HINCKLEY RAIL FREIGHT TERMINAL

Summary: Transport and Access

CPRE Leicestershire

Oct 2023

Figure 3.10: Forecast Trip Distribution for the Proposed Link Road (Northbound) for the 2026 and 2036 'With Development' Scenarios (in PCUs)

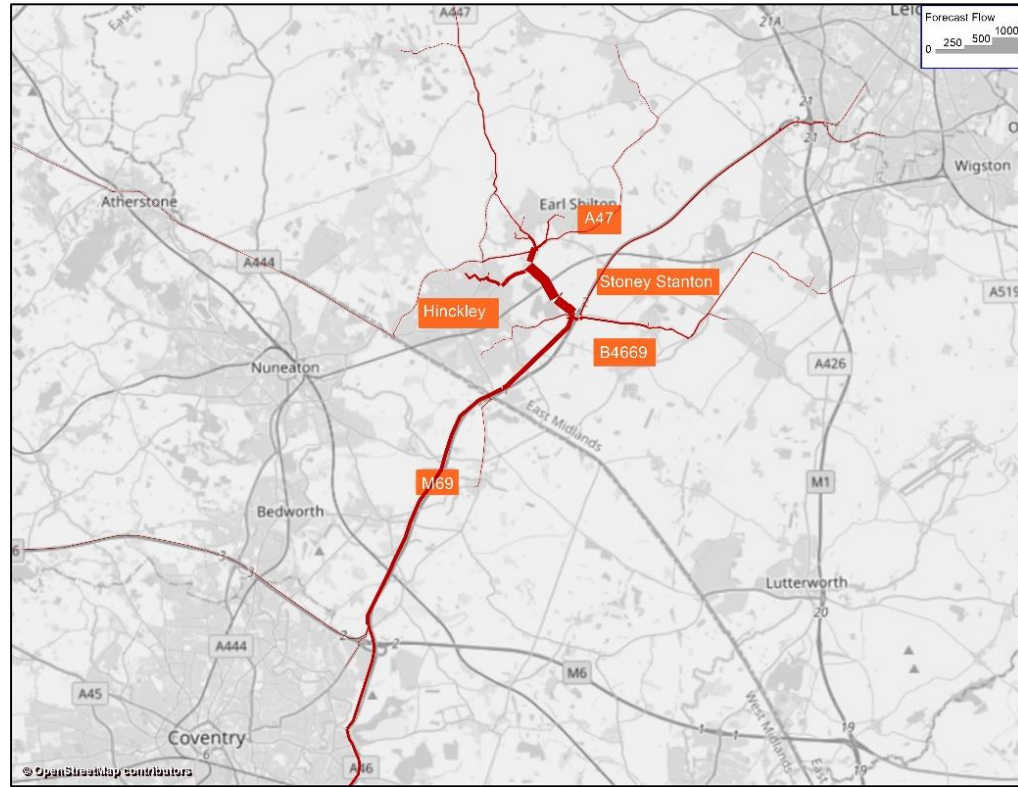
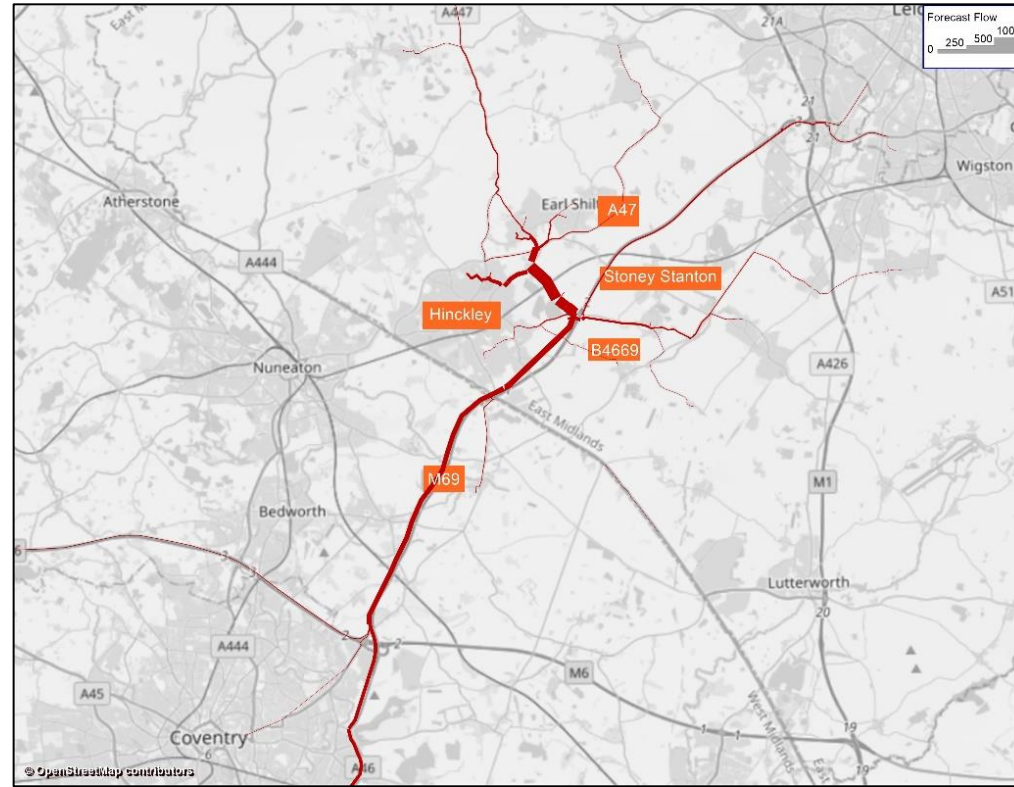
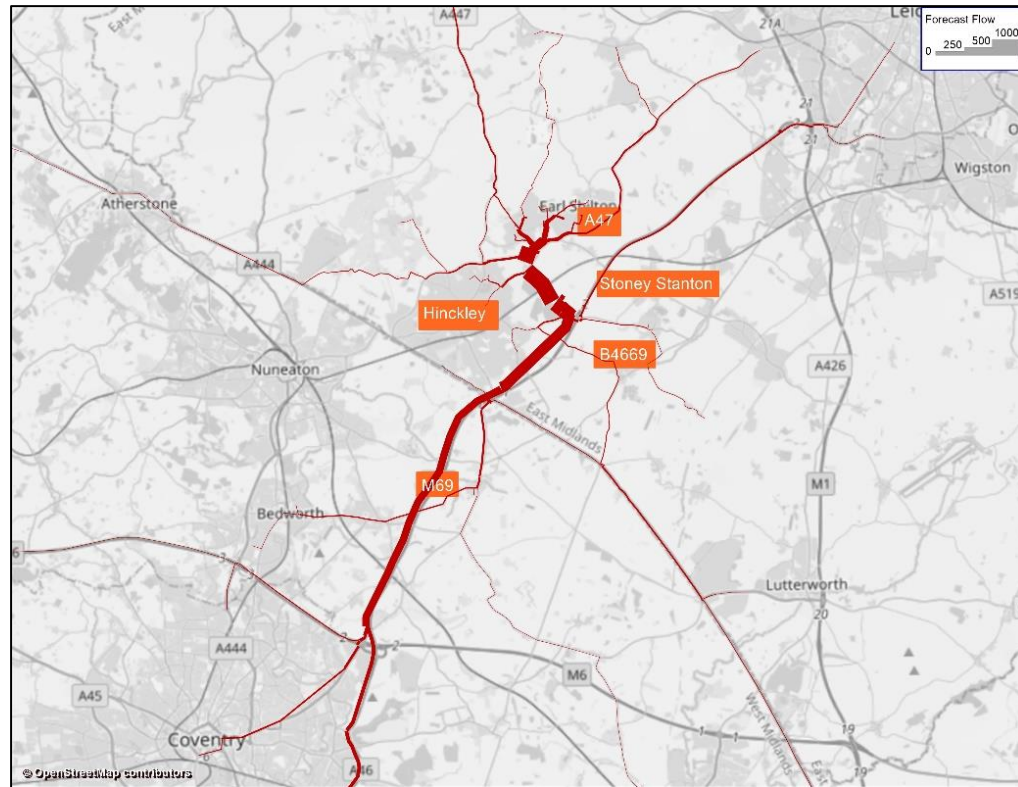
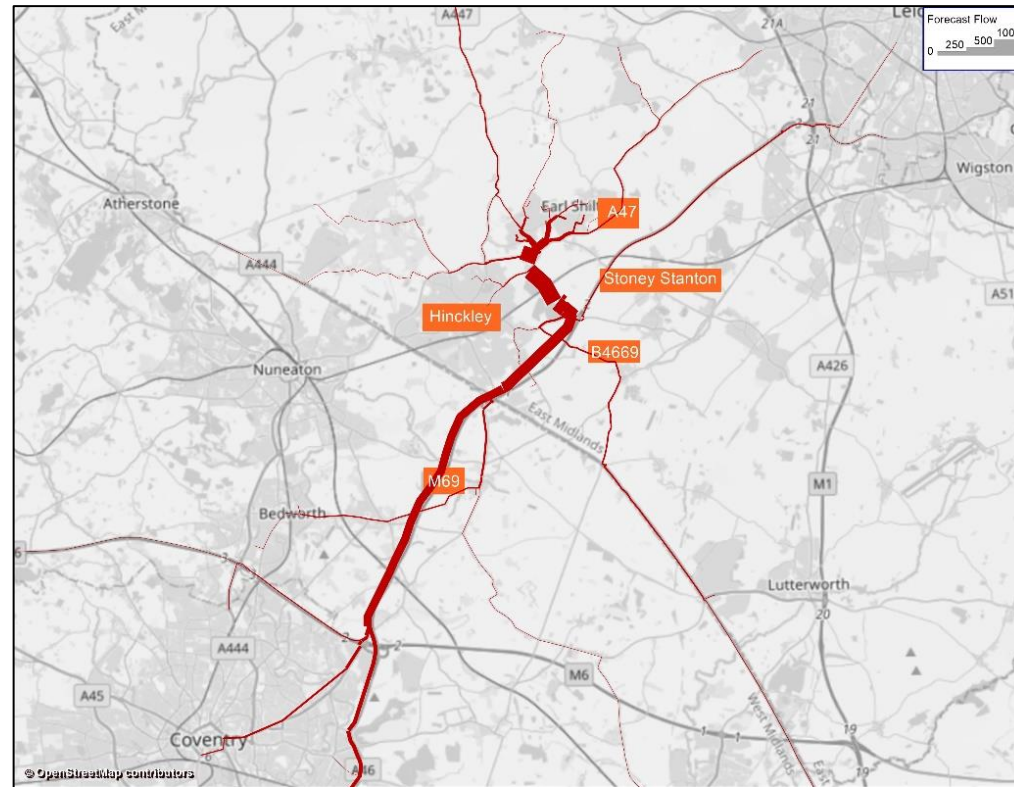
8.2.1 The site would be poorly situated for pedestrians. The entrance, via a newly constructed link-road, would not provide an attractive environment for pedestrians. Distances to the site would also be prohibitive.

8.2.3 The Assessment paints a glossy picture of potential improvements to the PROW network which is curtailed drastically between Hinckley and the motorway, as well as losing the opportunity to walk on the quiet Burbage Road. Pedestrians are forced onto the newly-constructed link road, then through the Industrial Park, or on a circuitous bridleway around the proposals. None would enjoy the attractiveness of the current routes through open countryside.

Figure 3.18 Forecast Junction Volume-Capacity Ratio for 2026 - AM Peak hour

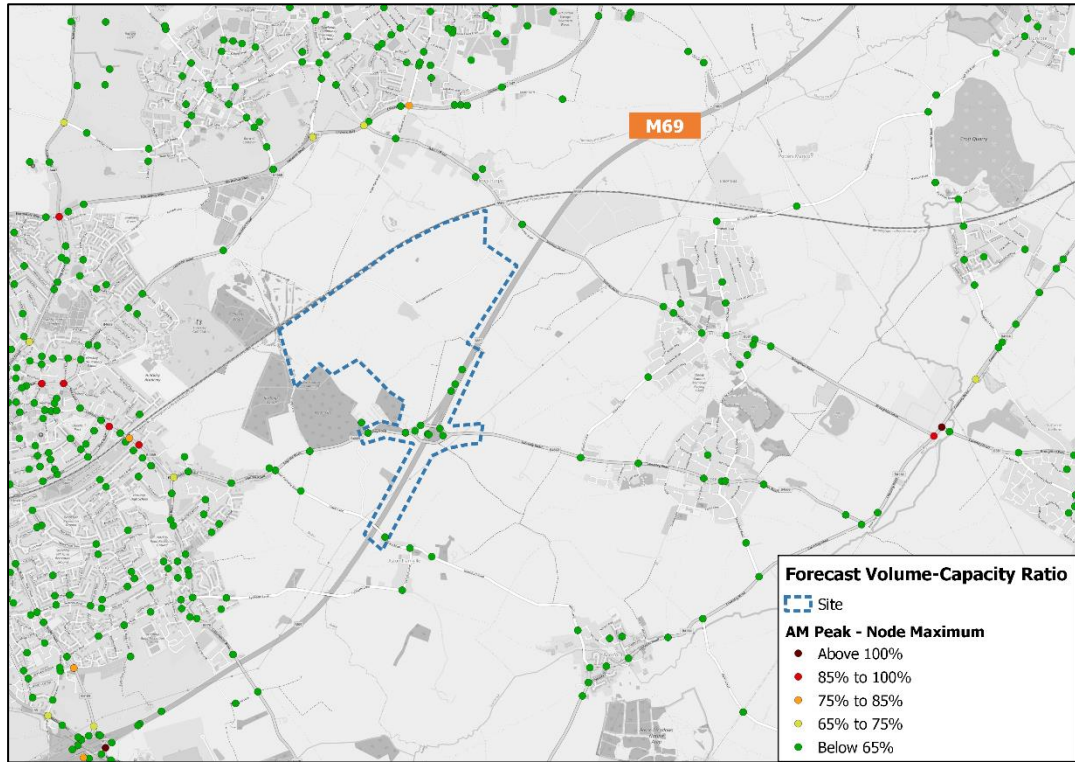
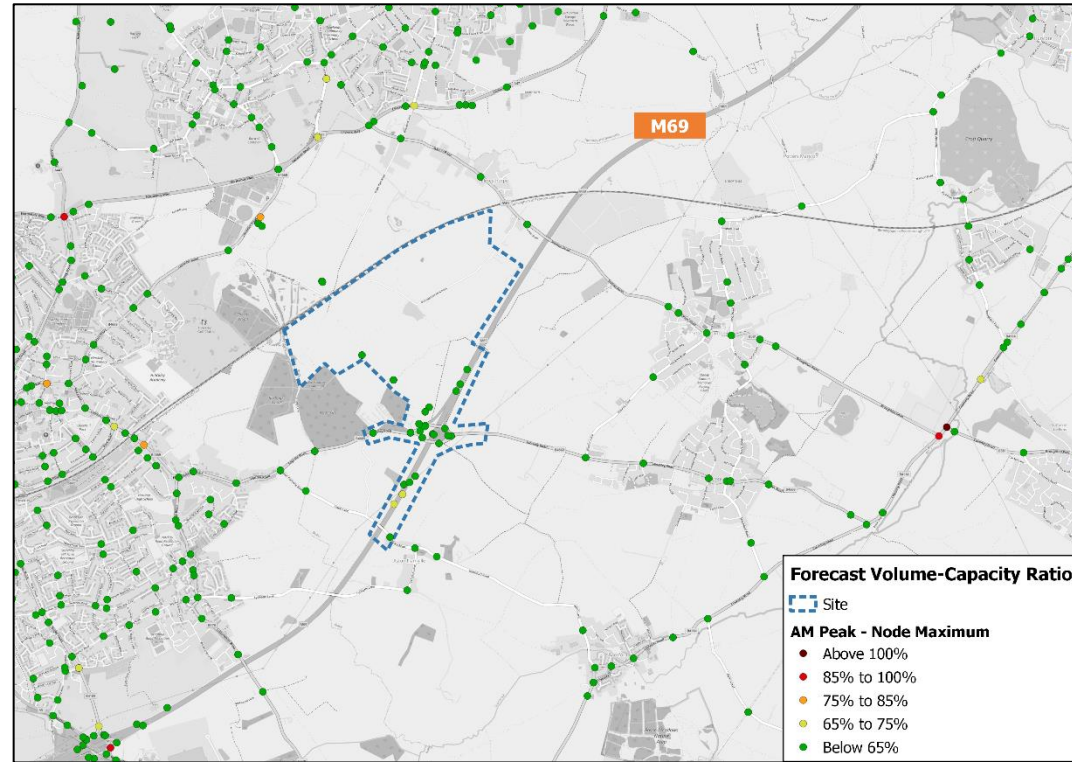
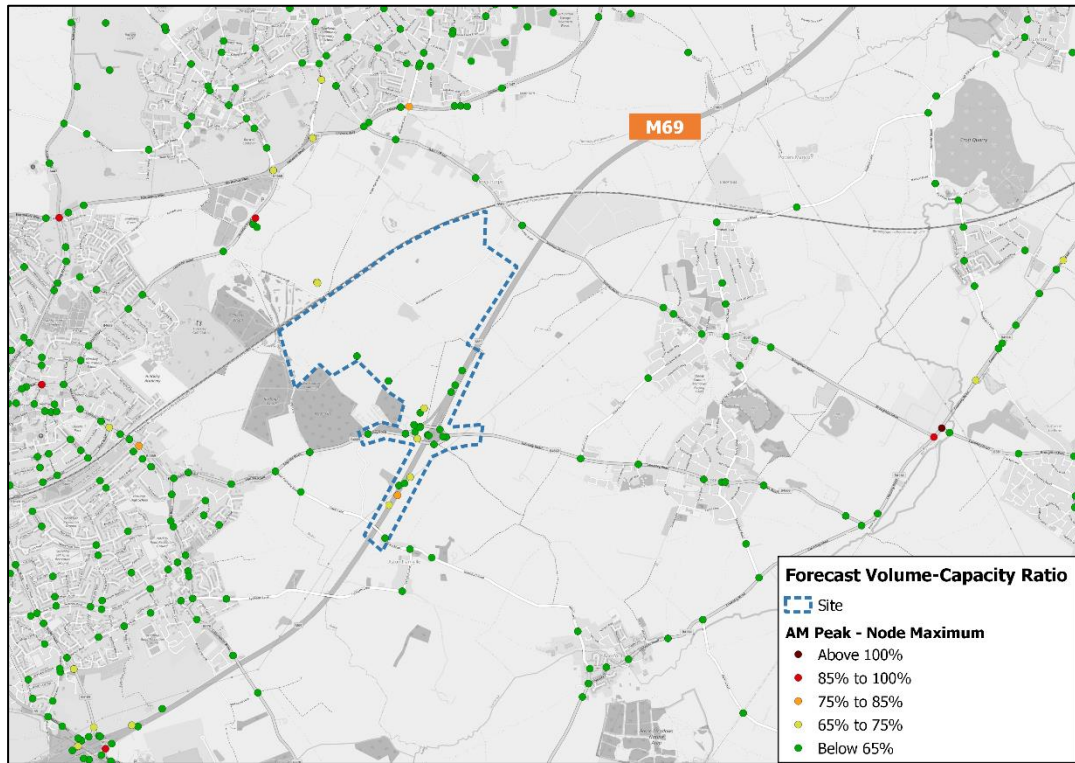
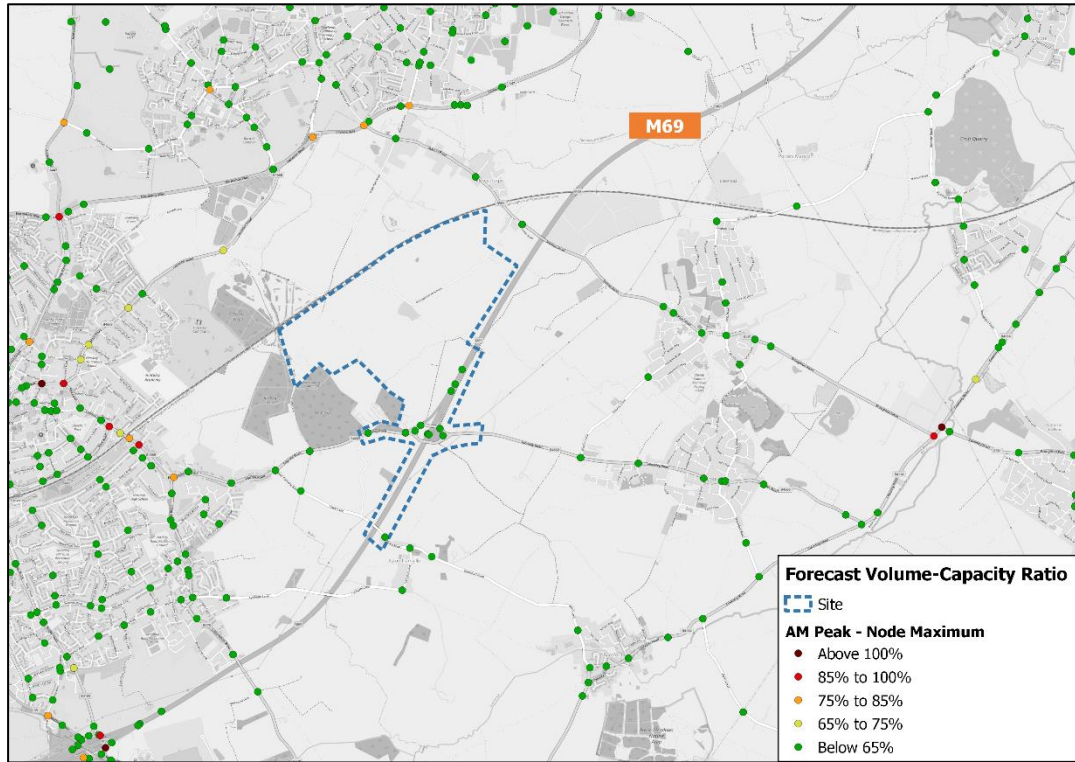
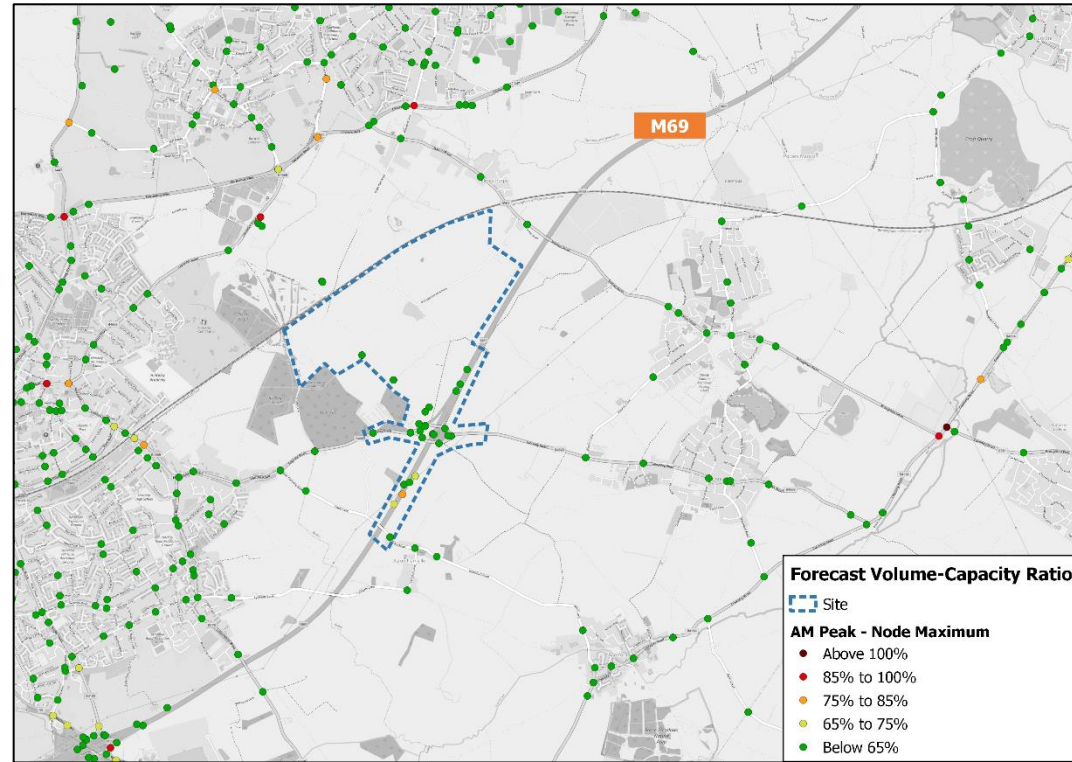
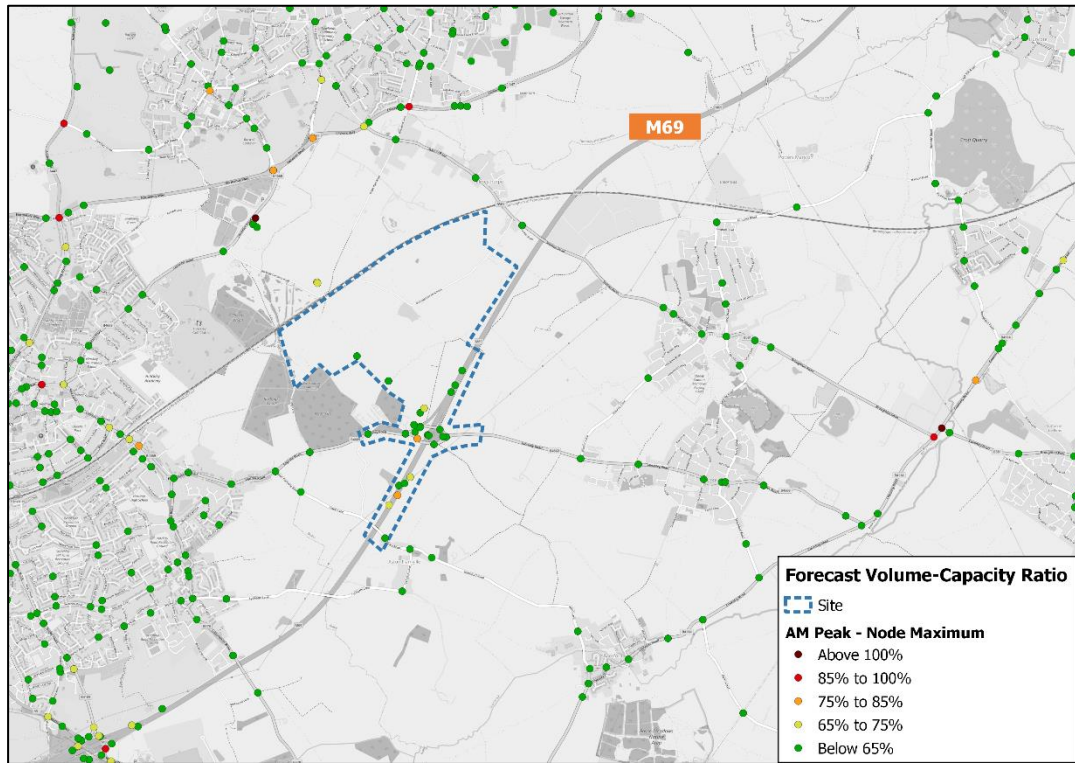
4.2 The introduction of Junction 21A led to a significant increase in traffic congestion between J21 and 21A. The heavily constrained J21 impacts on the functioning of the relevant strategic highways so modelled flow may be unrealistic.

5.6 Fourthly, the use of link data in the model may not account for network restraints, revealed in delay data.
